**EL PASO COUNTY PLANNING AND  
 COMMUNITY DEVELOPMENT  
 DEPARTMENT**

**STORMWATER MANAGEMENT PLAN CHECKLIST**

**PPR219**

GRADING & EROSION CONTROL PLAN
CLAREMONT BUSINESS PARK 2 FIL. NO. 1 - LOT 4
JOB NO. 44-037
DATE PREPARED: FEBRUARY 15, 2021
DATE REVISED: APRIL 21, 2021

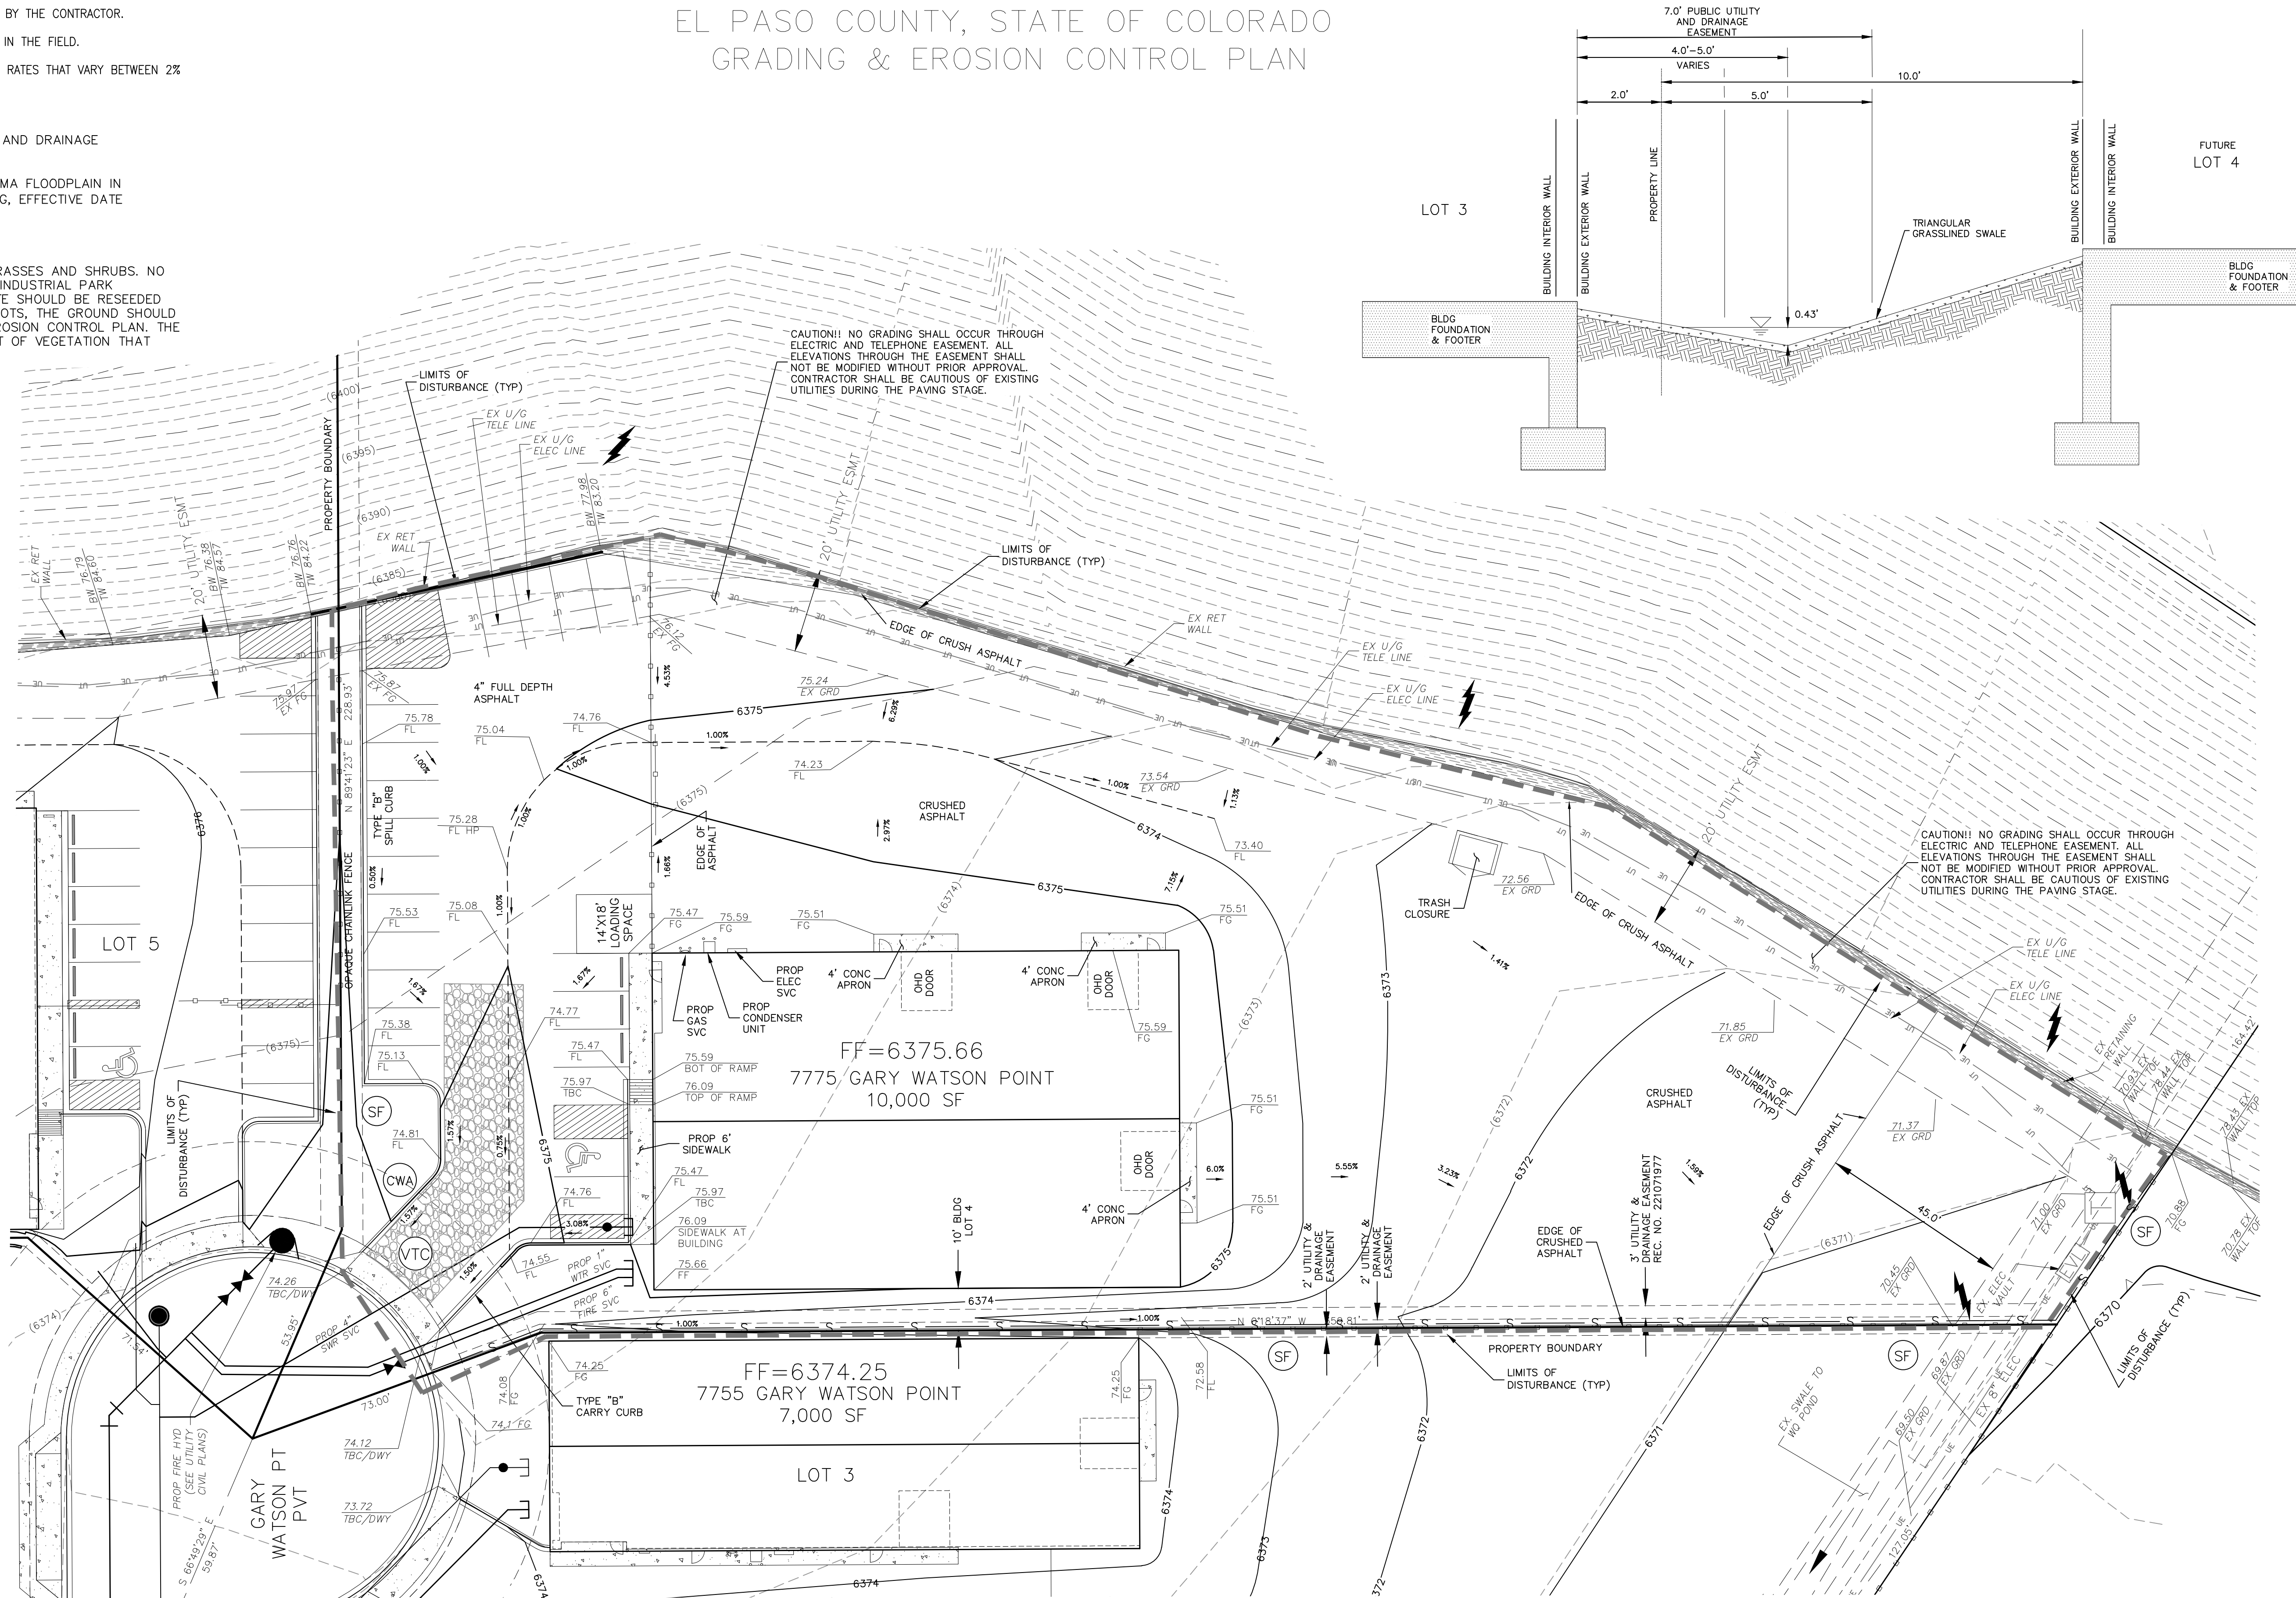
Revised: July 2019		Applicant	PCD
17	SWMP Map to include:	X	
17a	construction site boundaries	X	X
17b	flow arrows to depict stormwater flow directions	X	✓
17c	all areas of disturbance	X	✓
17d	areas of cut and fill		X
17e	areas used for storage of building materials, soils (stockpiles) or wastes	X	✓
17f	location of any dedicated asphalt / concrete batch plants	N/A	X
17g	location of all structural control measures	X	X
17h	location of all non-structural control measures	X	X
17i	springs, streams, wetlands and other surface waters, including areas that require maintenance of pre-existing vegetation within 50 feet of a receiving water	X	X
18	Narrative description of all structural control measures to be used. Modifications to EPC standard control measures must meet or exceed County-approved details.	X	✓
19	Description of all non-structural control measures to be used including seeding, mulching, protection of existing vegetation, site watering, sod placement, etc.	X	✓
